26 November 2019

Submission - Bella Vista Station Precinct Concept Proposal SSD-10344

Figure 4: EIS Ground Floor Setbacks (left) and as amended by the RtS (right)

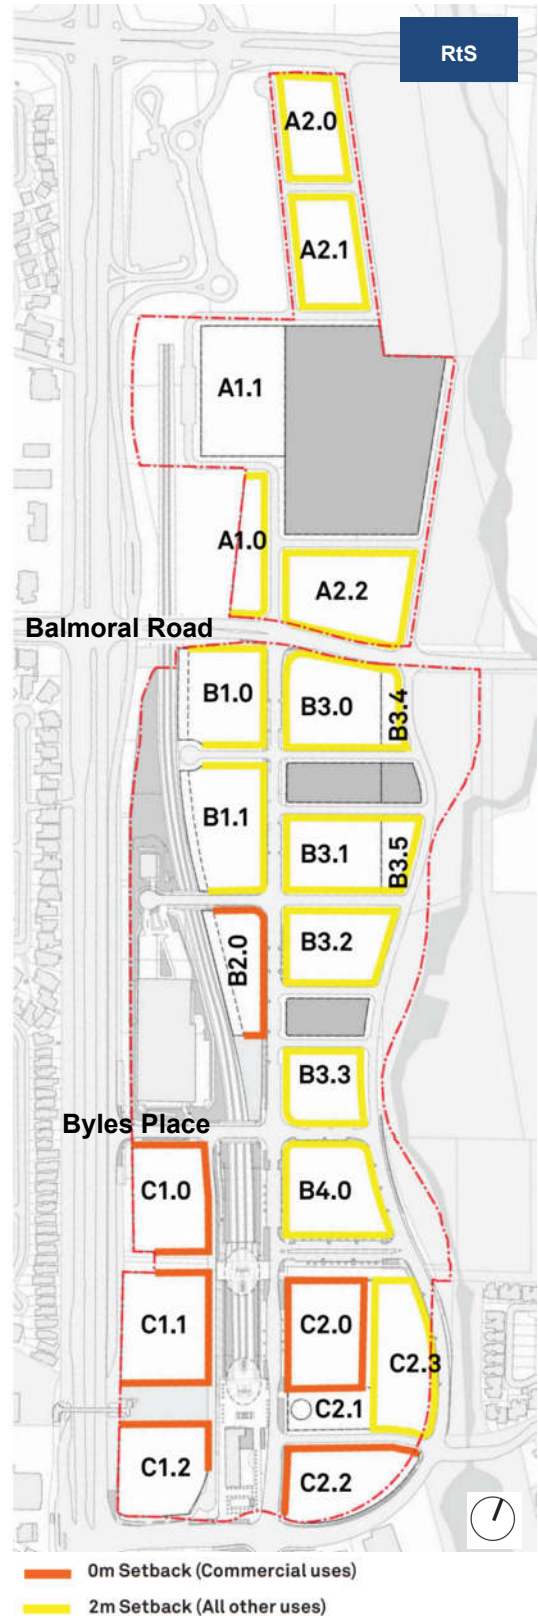
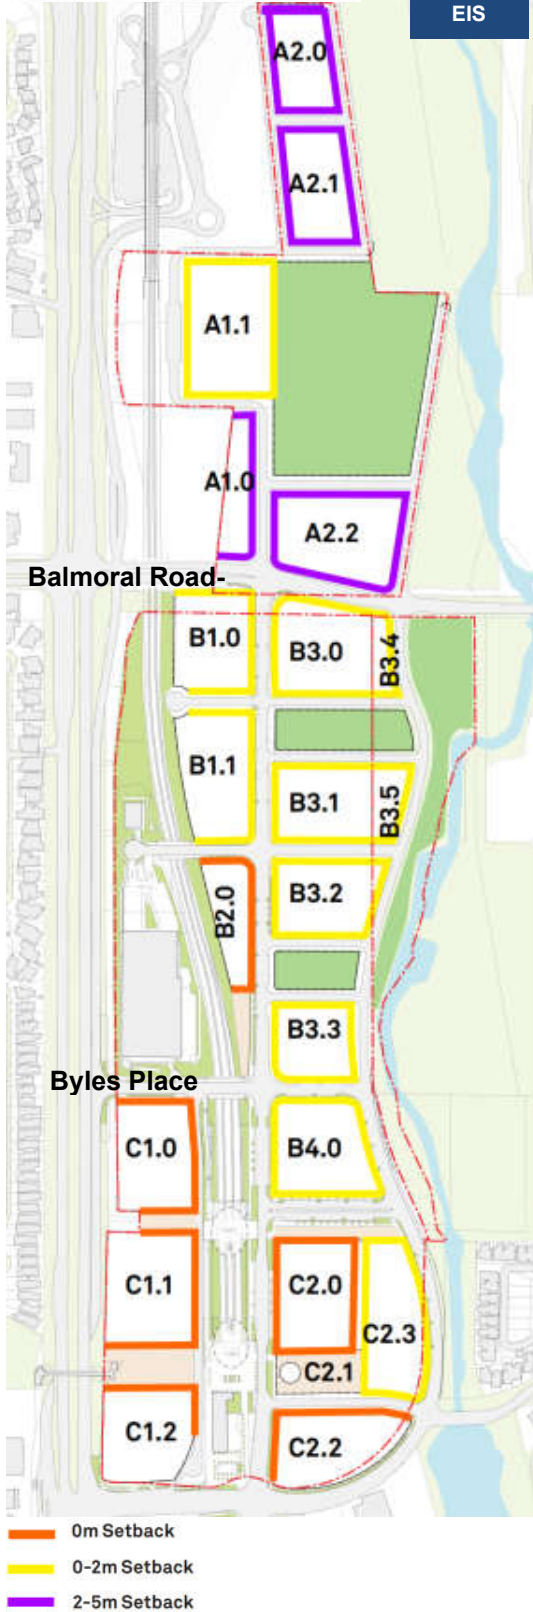
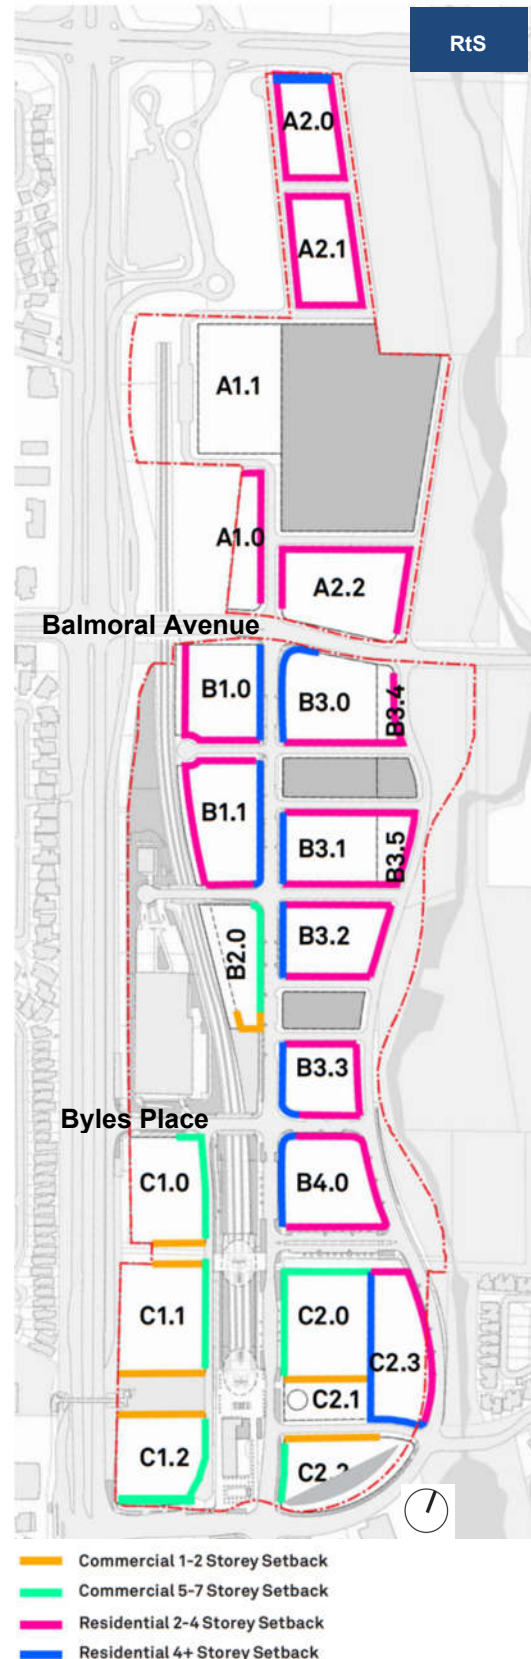
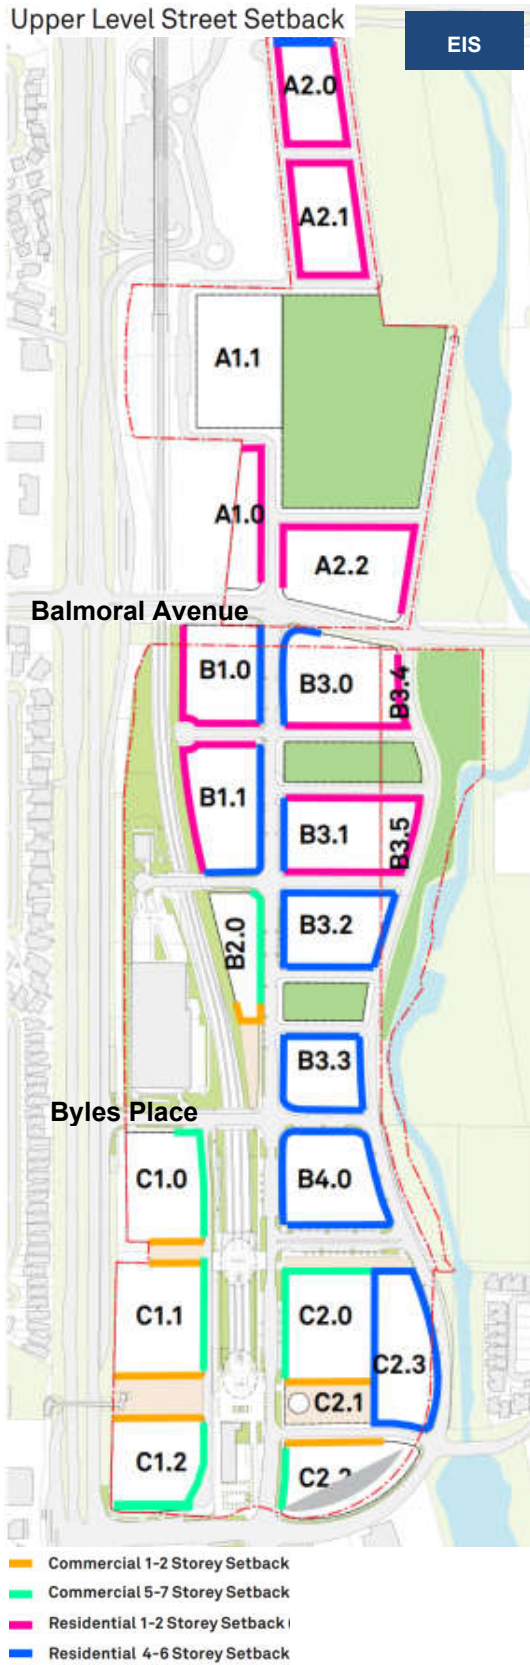
The building setbacks for the blocks that are directly opposite my property are C2.3 as shown in Figure 6 and Figure 7 below.

The setback treatment on the ground floor are shown as 0 – 2 metres, while the levels 4 – 6 storeys is setback only 3 metres (reference to Figure 2.1 & 2.2 from Design Guidelines). **This setback treatment is considered as minimal and does not adequately allow any significant area for landscaping in the front setback.**

This section of Celebration Drive is the closest point to the existing dwellings and our dwelling is one of the closest in the group of dwellings in our complex to the future development site. **The minimal landscape setback is adversely affecting the opportunity for adequate landscape treatment to provide a buffer to the future buildings.**

There is no reason for this setback being as reduced as other areas along Celebration Drive have a greater setback being some 2 – 5 metres on the ground floor and 5 metres on the upper floors. The treatment should be amended to have regard to the closet point to the dwellings and provide more opportunity for landscaping.

It is strongly suggested that the building setback should be increased on Celebration Drive with Block C2.3, which should be setback 2 – 5 metres on the ground floor for landscaping.
